Our Ref: ID 3576
Your Ref: SSD-83258708

State Significant Development Application for EIS Florida Street, Sylvania, Affordable Housing SSD-83258708

Thank you for the opportunity to provide advice on the State Significant Development Application for 29 Florida Street, Sylvania. It is understood that the proposed development undertaken by Homes NSW consists of both social and market housing and seeks to construct eight residential buildings with a total of 484 dwellings, completed in 2 stages comprising:

Map 16 - PMF - Design Scenario - Flood Hazard

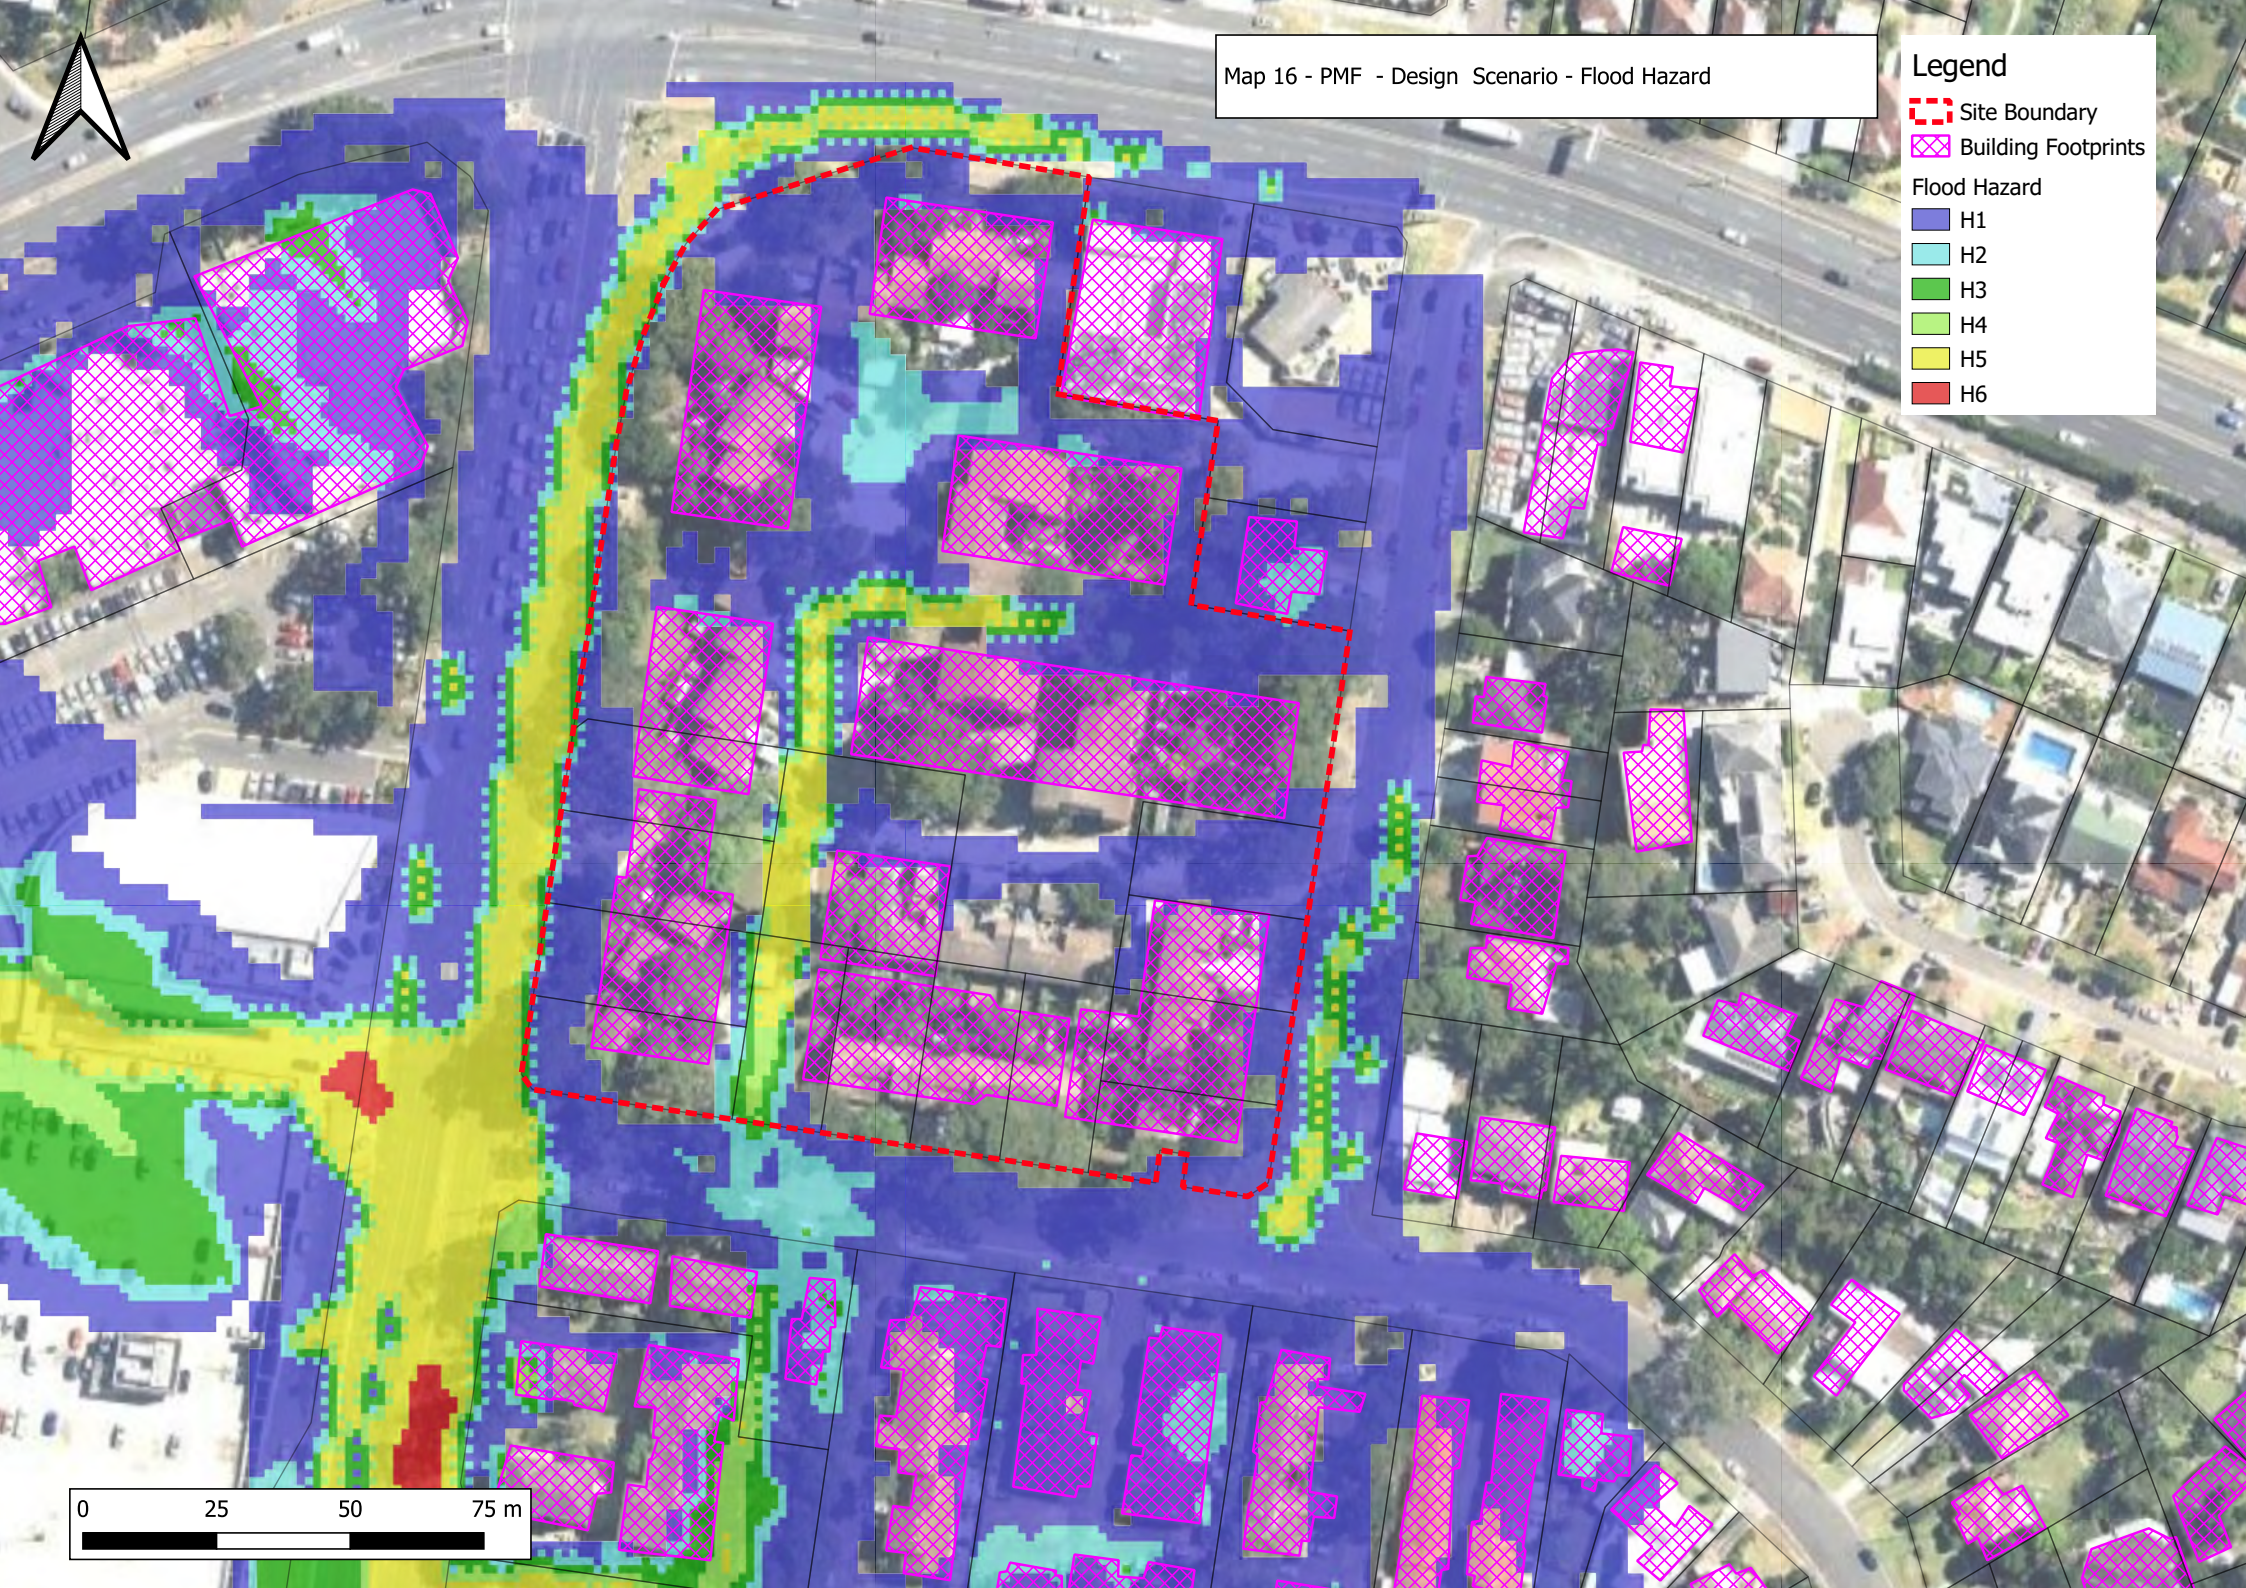
- **The proposed design increases flood hazard within the site posing a risk to life to site users.** By including the proposed mitigation measure of *"the channelisation of overland flows within the Site to the internal roadway"*⁴ the hazard within the site itself is increased in all flood events from the 20% AEP flood,⁵ with flooding within the site during the PMF increasing from H2 to H5.⁶
- **The proposal has not demonstrated consistency with the [Shelter-in-Place Guideline](#)** (NSW Government, 2024). The consent authority should request the proponent to demonstrate consistency with the Shelter-in-Place Guideline prior to granting

special engineering design and construction. During the PMF event under existing conditions flooding within the site is limited to H2,¹⁶ which is unsafe for small vehicles, while under proposed conditions it contains a H5 flow path through the site.¹⁷

This increase in hazard within the site, as well as the existing high hazard of surrounding roads is inconsistent with the [Shelter-in-Place Guideline](#) (NSW Government, 2024). The consent authority should request the proponent to demonstrate consistency with the Shelter-in-Place Guideline prior to granting consent, to ensure the risk to life is adequately managed and/or mitigated. This includes addressing consideration 8c. development is not subject to high hazard flooding or surrounding roadways are not subject to high hazard flooding. Applying a shelter-in-place strategy to new development surrounded by high hazard flooding poses a risk to life to site users who may attempt to leave or re-enter the site if they become trapped outside the site during flood events.
